**SSD-9264 - DEVELOPMENT APPLICATION EXHIBITION – TAMWORTH SOLAR FARM – 2209 SOLDIERS SETTLEMENT**

I refer to your correspondence received 23 January 2020 in relation to the exhibition of a Development Application for the Tamworth Solar Farm at 2209 Soldiers Settlement Road, Somerton requesting Tamworth Regional Council to comment on the proposal and provide advice including recommended conditions of consent. In this regard, the following information is provided:

Figure 1-7: Topographical view of sight distance at Babbins Road and Warminster Road Development Area

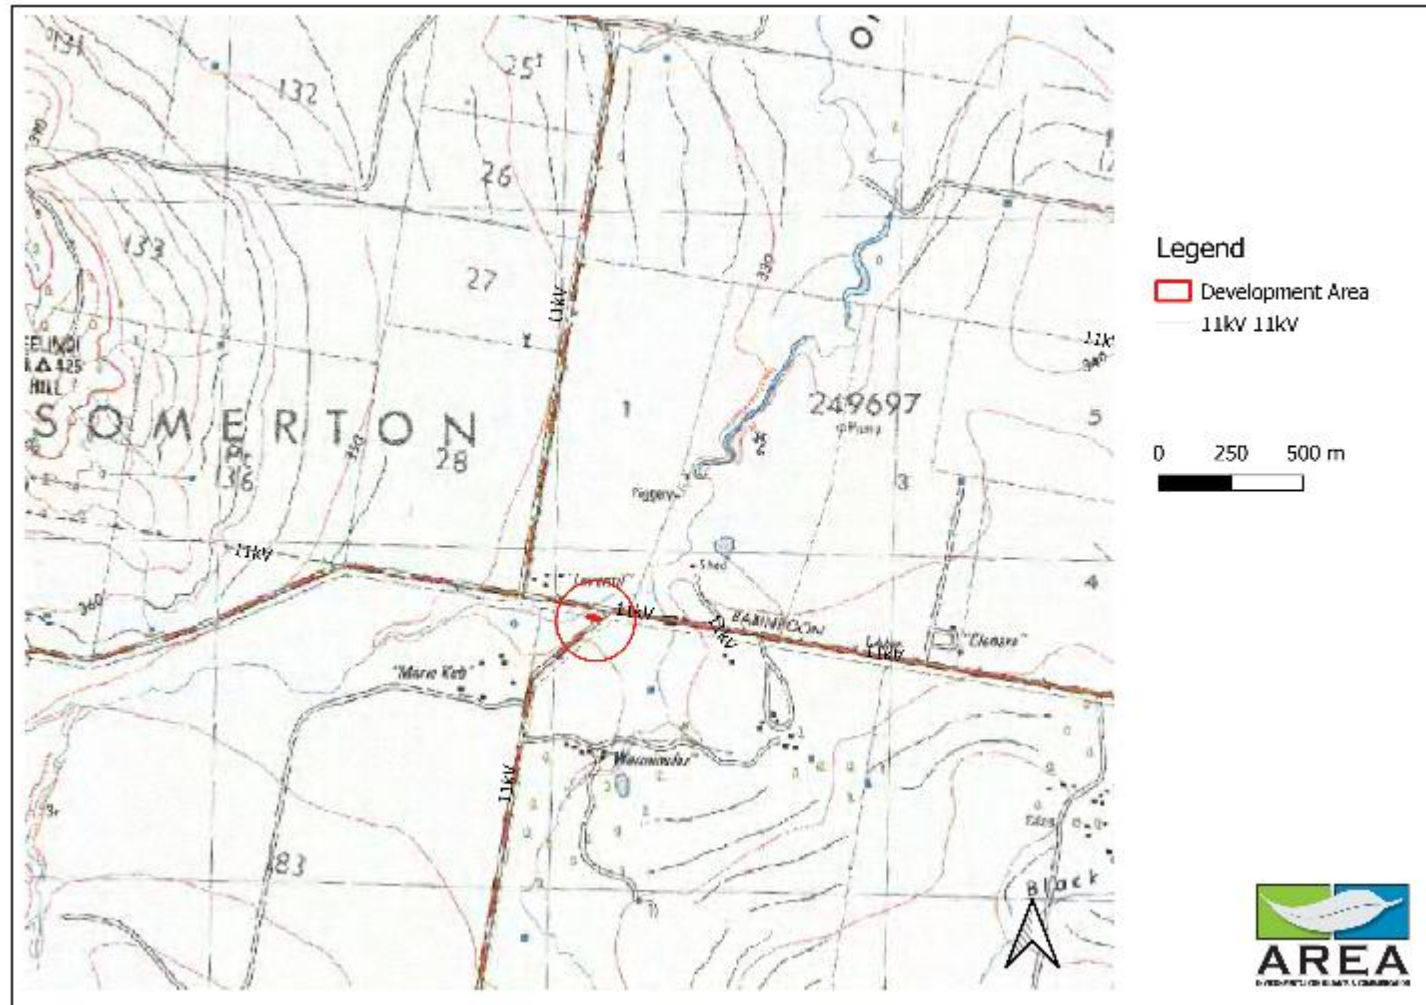
1. The intersection of Warminster Road with Babbinboon Road is discussed in the EIS and the associated Traffic Impact Assessment. However, the documentation is silent on the matter of the poor angle of approach on the minor leg of this intersection. This element should be investigated in detail, and the geometry revised if required.

2. The Traffic Impact Assessment recommends the removal of an existing tree at the intersection of Warminster Road with Babbinboon Road with the objective of improving sight distance to the west. This tree is likely to be contributing the stability of the watercourse in this location. Consideration should be given to under-pruning the tree as an alternative to removal.

Figure 2-3 – Extract from Austrorads Part 6 of Guide to Traffic Management showing requirements for left turn deceleration lane to be provided (AUL(S))

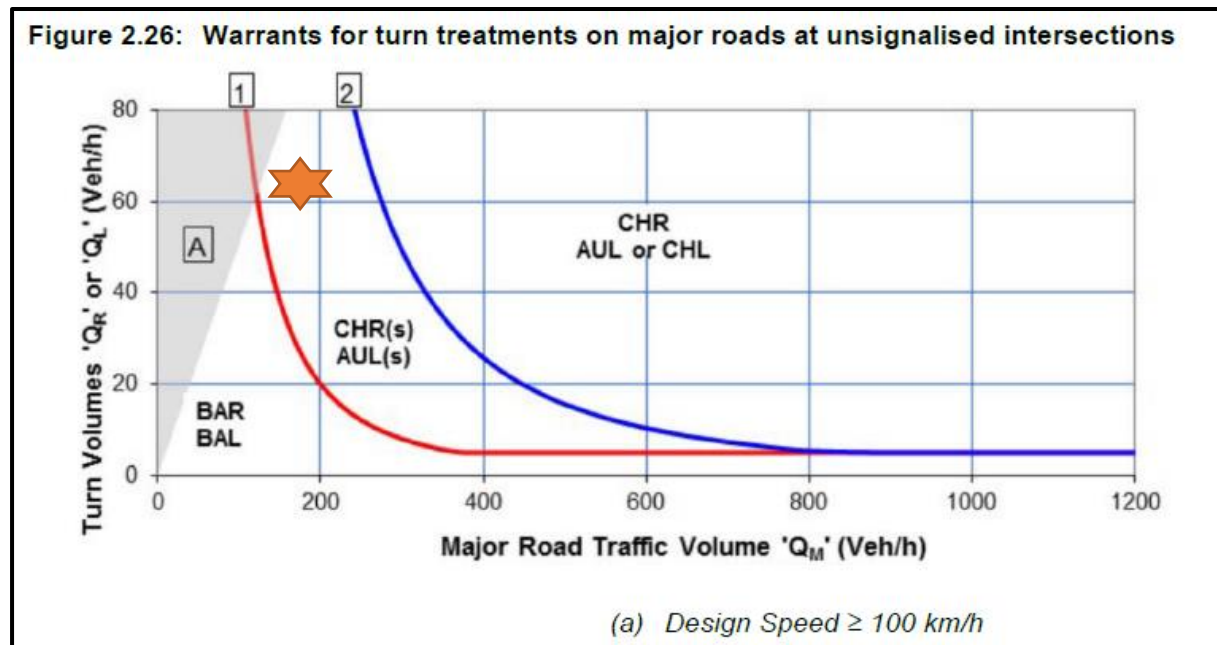
It is acknowledged that an intersection upgrade will be undertaken at the Oxley Highway/Babbinboon junction and the Proponent will be required to enter into a Works Authorisation Deed with the Roads and Maritime Services for those works to be designed and construction appropriately.

Figure 4-1 – Heavy and Light Vehicle access route to subject site for construction traffic

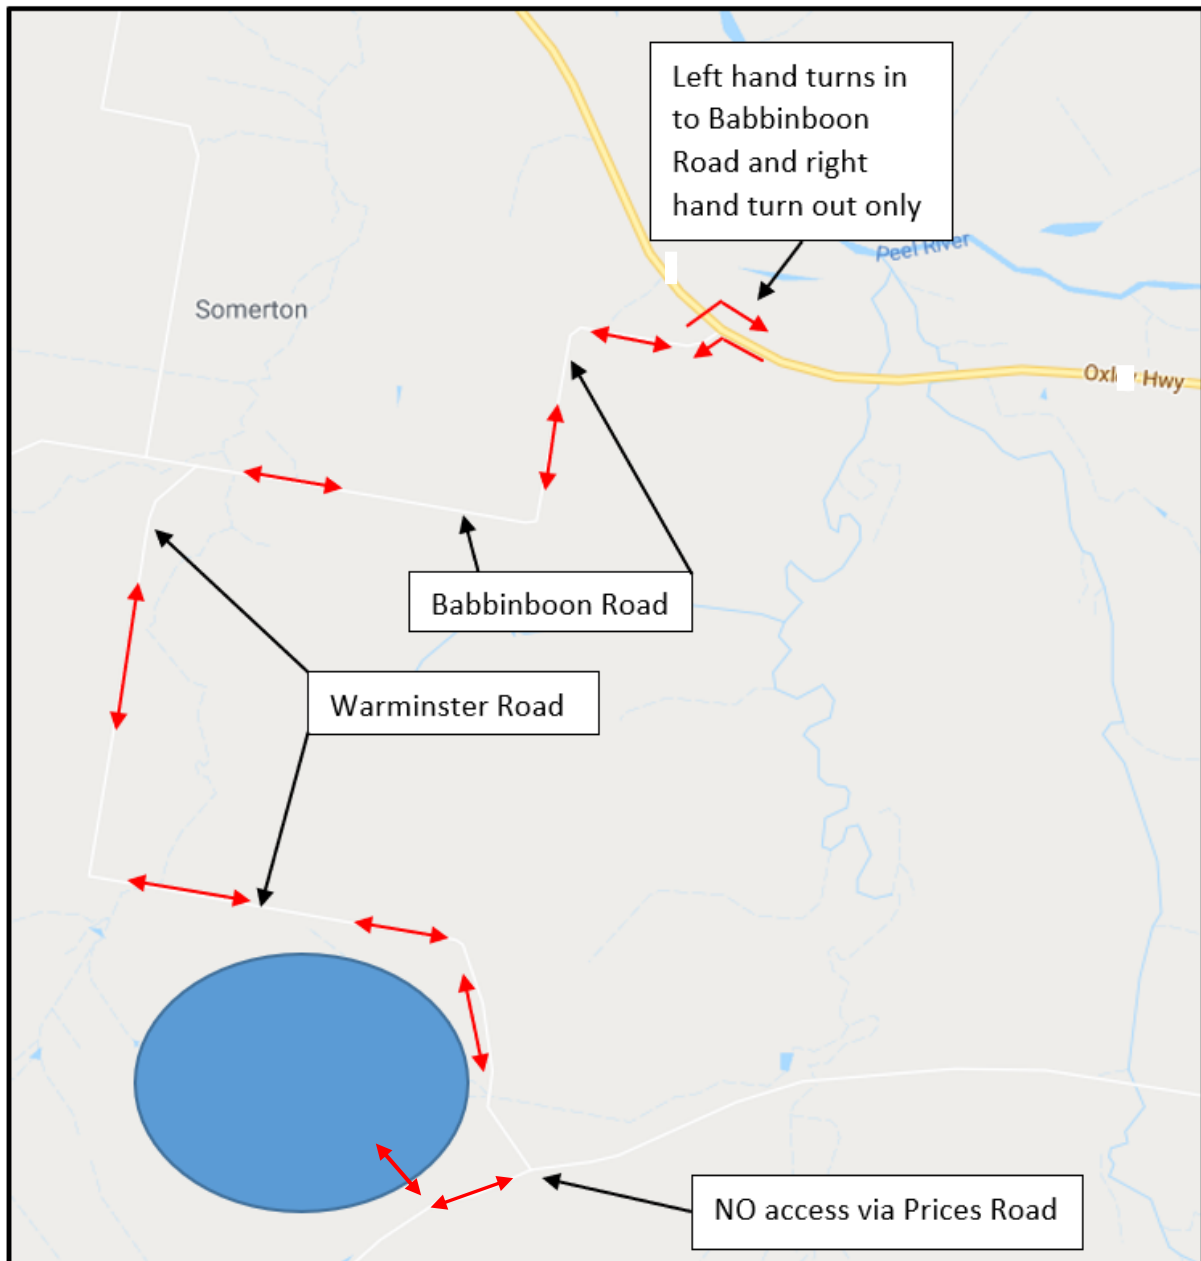
Whilst it is noted in the EIS that along the transport route from the Oxley Highway to the Site entrance, bends and intersections will be sealed, Council requests that further improvements to other sections of road along the transport route between Oxley Highway and the Site be undertaken. The following comments are made in relation transport route road infrastructure and traffic movements.

Concerns are raised by Council and nearby residents due to the proposed increase of construction traffic along Babbinboon Road, Warminster Road and Soldiers Settlement Road (the transport route) and the limited capacity for these roads to carry a significant increase in light and heavy vehicle movements without substantial upgrades pre-construction and without ongoing monitoring of road conditions throughout construction (including upon completion) of the development.

3. Several sections of unsealed roadway along the proposed access route are low-lying, resulting in inundated and trafficable shoulders and swale drains during wet weather. Concern is raised with regards to the ability of the roadways to adequately cater for passing vehicles under these conditions. This aspect should be investigated, and upgrades recommended where appropriate.

Council requests the transport route to be upgraded (at a minimum) to allow a two truck width road to safely carry the traffic in all weather. This would also include sealing further sections that are currently inadequate in wet/dry times. The EIS suggested that a dilapidation survey be conducted on the road networks prior to construction. Council agrees that a dilapidation survey should be required. This survey should be the basis for determining the level of upgrades required for the transport route.

- *Prior to commencement of construction of the project, in consultation with Council and the RMS, the Proponent shall identify any upgrade requirements to accommodate project traffic for the duration of construction (including pavement, shoulder, swale, culvert, causeway, bridge and drainage design; intersection treatments; vehicle turning requirements and site access) considering final traffic volumes and works.*
